RE: CAO15-001 & VAR 18-002  
MI Treehouse, LLC

I request this letter to be submitted as an exhibit to be considered by the Hearing Examiner, John Galt, or his replacement, during the public meeting to be held Dec. 2, 2021, at 9:00am by a Teams Conference Call regarding the MI Treehouse, LLC applications for a Reasonable Use Exception and a Zoning Variance for property located at 5637 E. Mercer Way, Mercer Island, WA 98040 (File Numbers as referenced above).

SITE PLAN
5637 MERCER WAY
MI TREEHOUSE, LLC
 11030 SE 30TH ST
 BELLEVUE, WA 98004

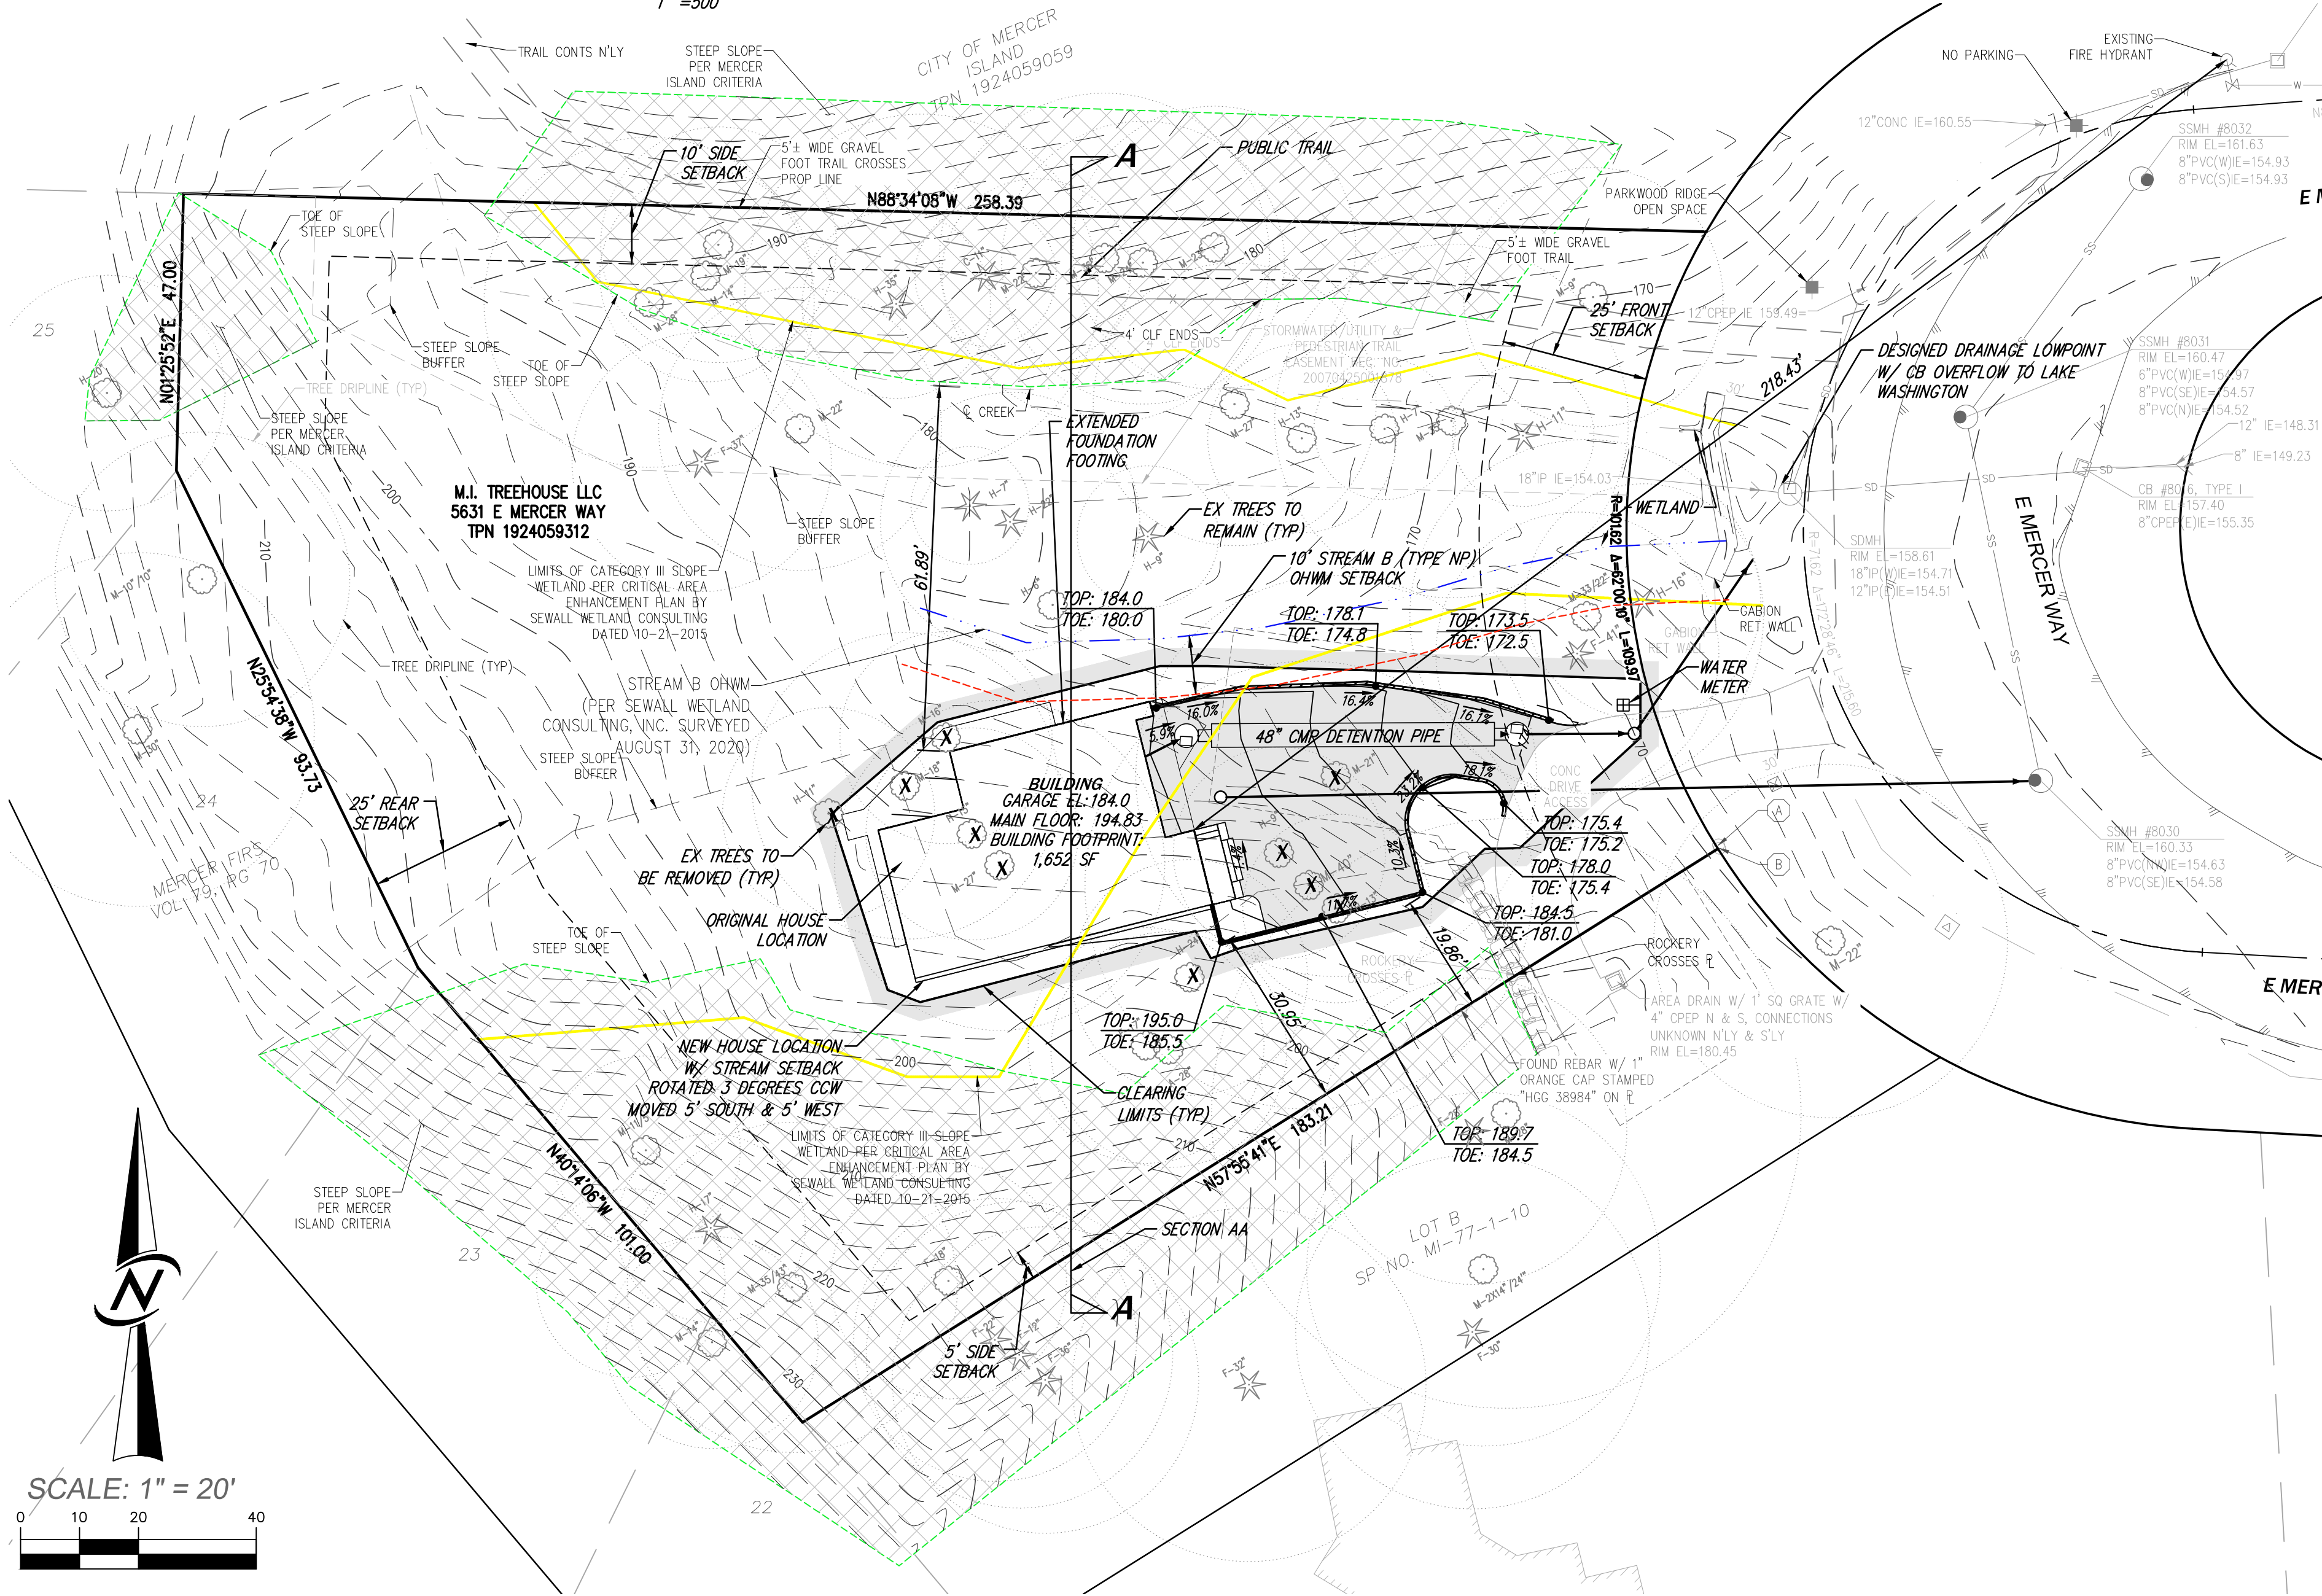
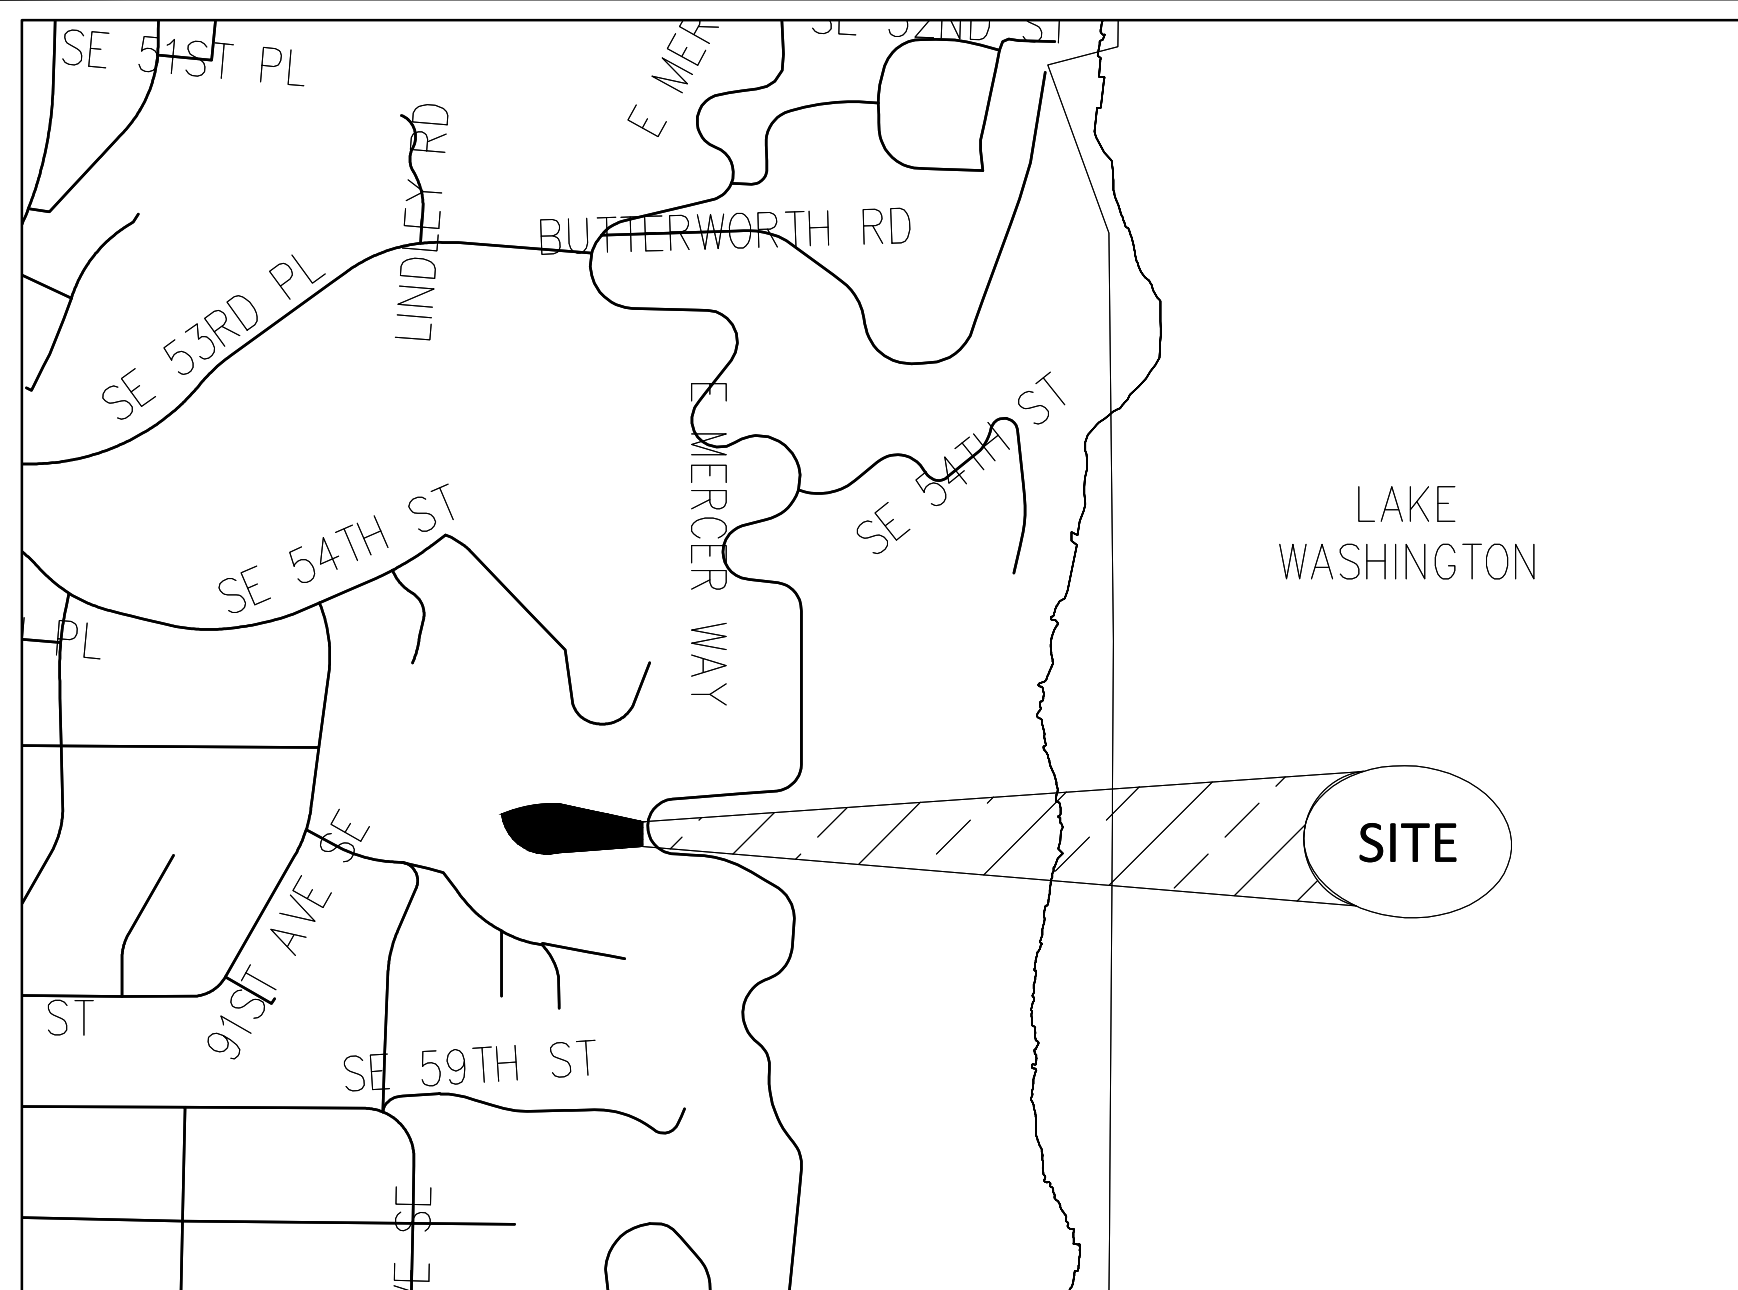
**3)** Exhibit 87b 18039 MI Treehouse Site Plan (2021-07-29) is the site plan used by the City in it's Staff Report. This Site Plan is not dated and there are discrepancies between this Site Plan and the Core Survey dated 8/31/20 Exhibit 80f. Therefore, it is not clear that the Staff was using the most recent site survey. Most of the discrepancies are the locations and number of trees on the property. The Site Plan shows far fewer existing trees.

**7)** The latest site plan used by the City (Exhibit 87b) shows a 48-inch detention pipe while the drainage plan (Exhibit 84) shows a 60-inch detention pipe. Which is it? How long will the detention pipe be, how close to the southern stream will it be, how deep will the trench have to be to bury the detention pipe and how will the de-watering of the area be handled? What water flow measurements have been taken and during what time of year to determine the size, depth, and material to be used to construct the perf drainage system surrounding the detention pipe?

DATE: 2018-06-13	DESIGNED	DRAWN: NRR	APPROVED: KWS
SHEET	1	OF	1
PROJECT NUMBER	18039

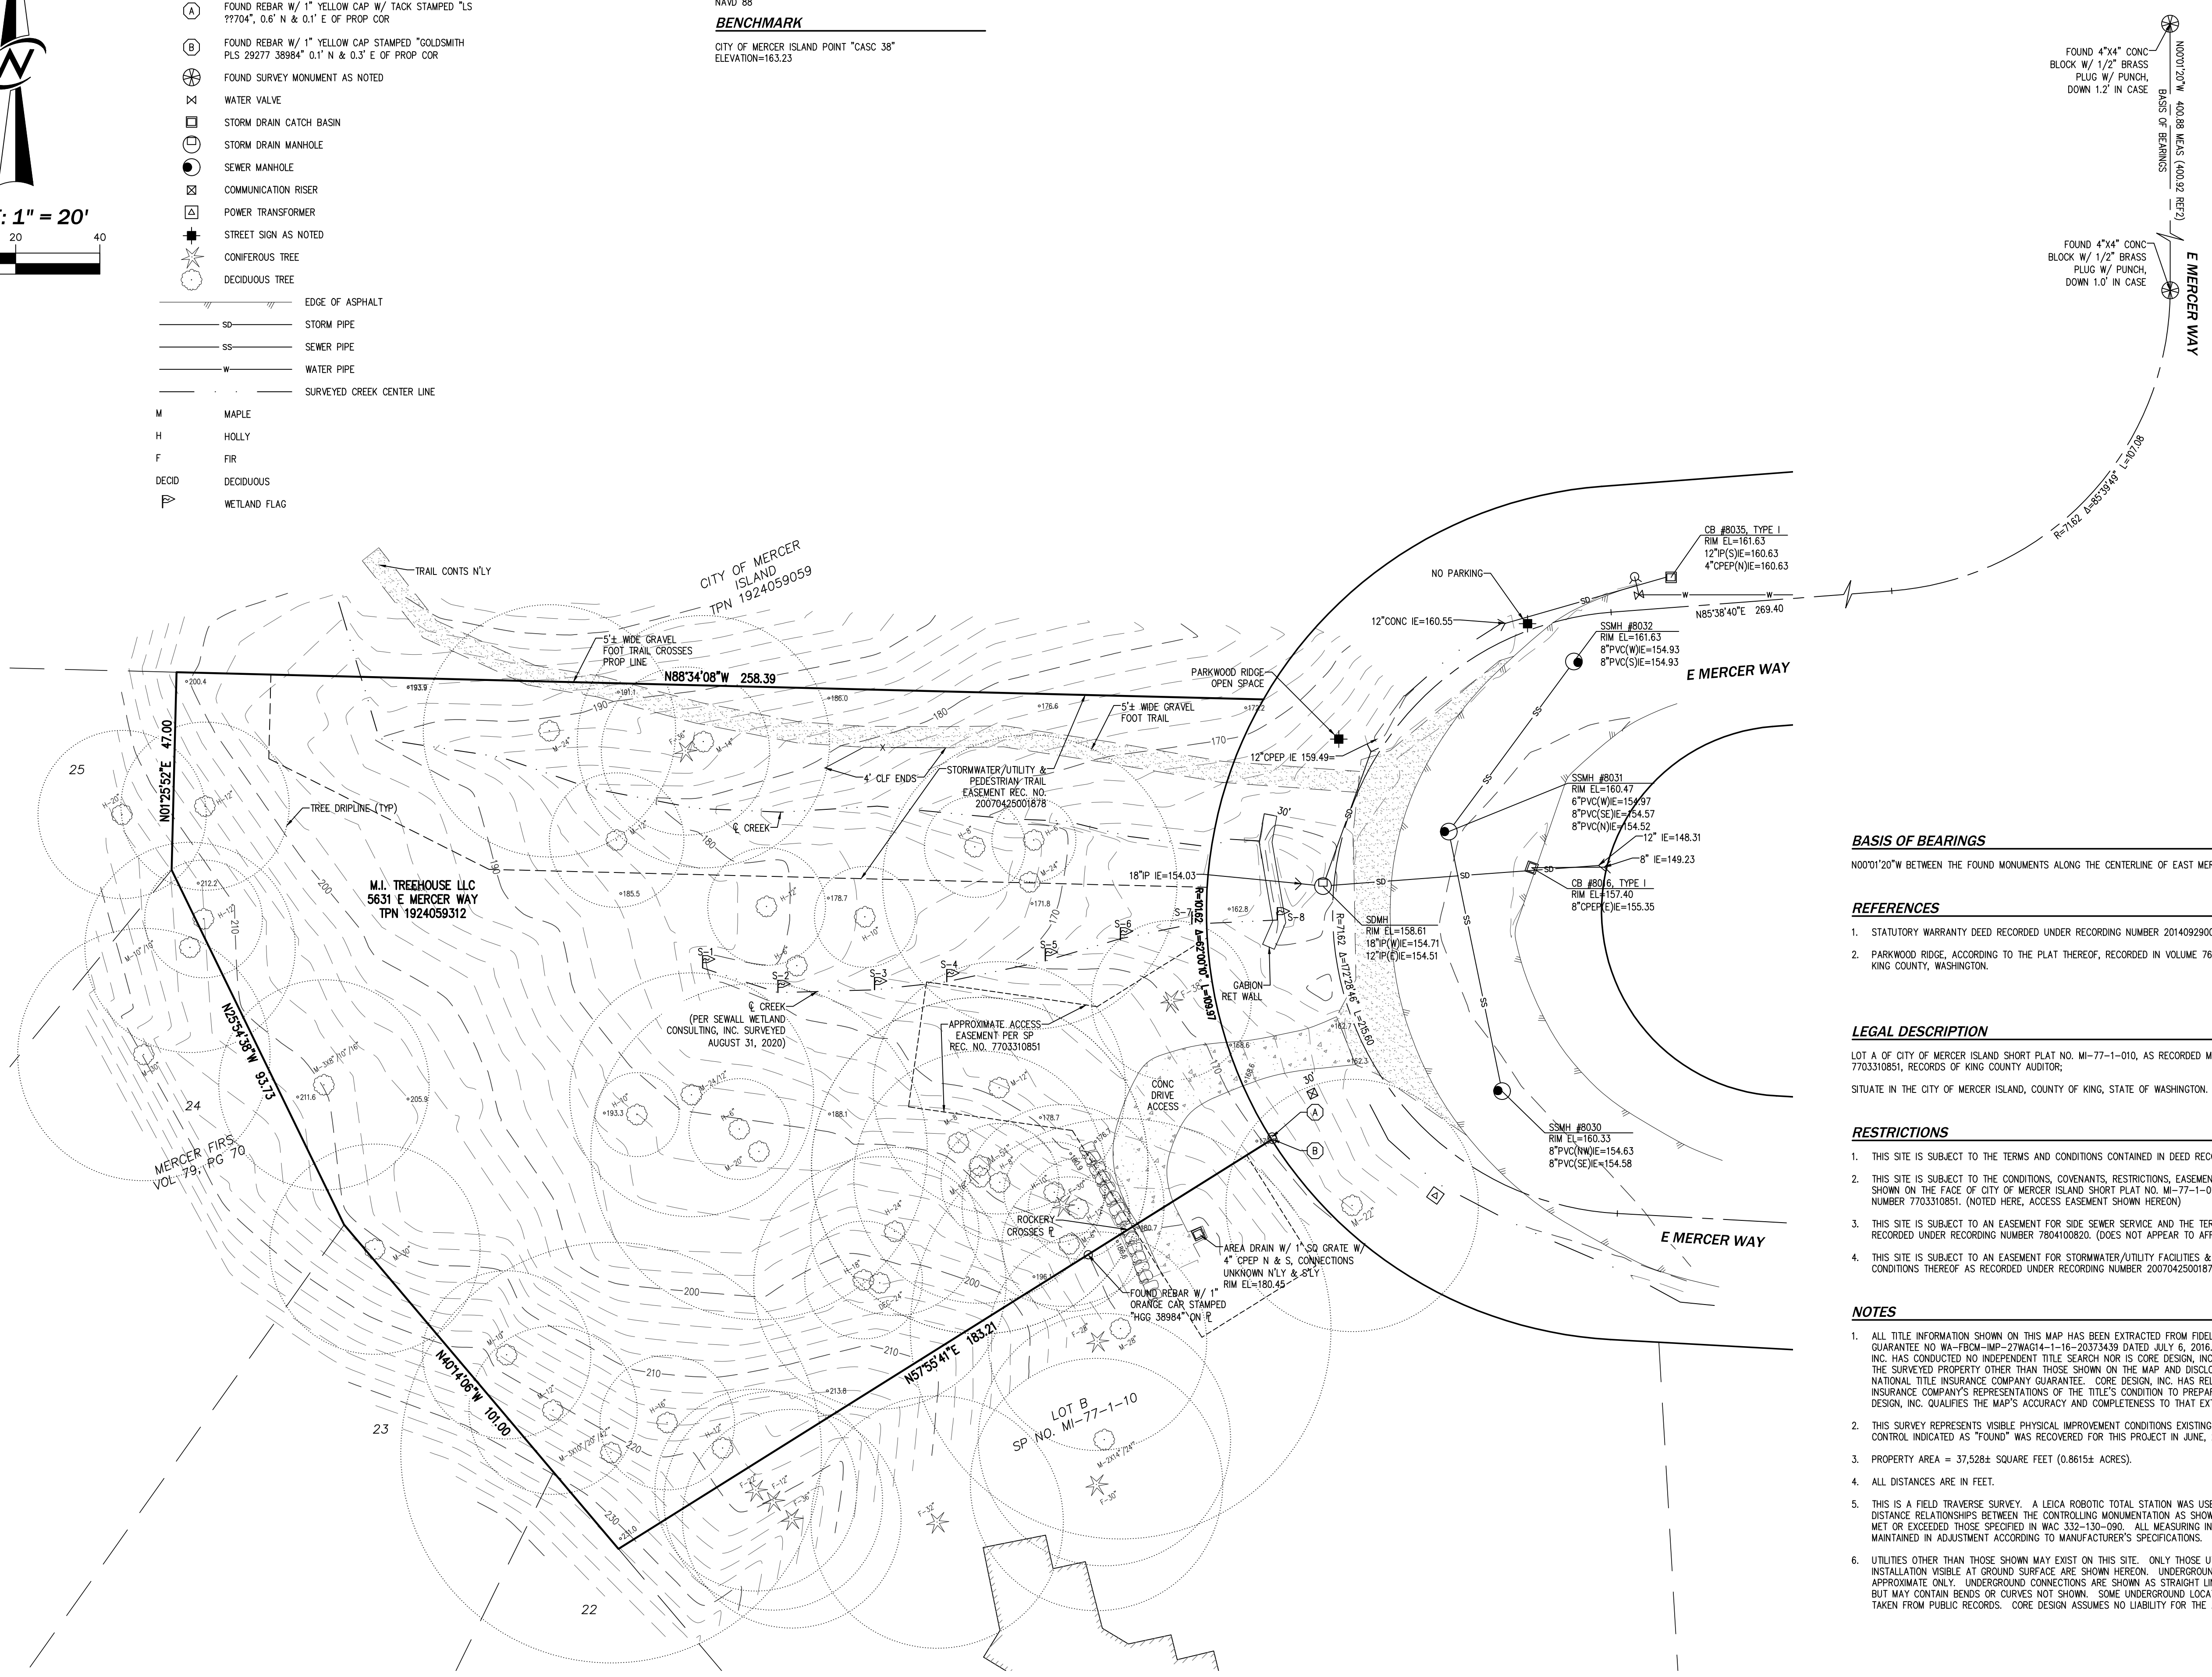
**2)** The updated Core survey dated 8/31/20 Exhibit 80f appears to now show the proper location of the southern critical stream B, however, the survey is incomplete as it fails to show the multiple smaller flowing streams that feed into the primary stream shown in the Core survey. The “feeder” streams are predominantly south and west of the primary southern stream and

the proposed house will be located on top of the feeder streams. The southern stream shown on the survey is like a tree trunk – what is missing is the equivalent of the tree branches – the feeder streams to the primary stream. Below is a picture of one of the feeder streams that feed the primary southern critical stream. The feeder stream below runs directly through the location of the proposed house foundation.
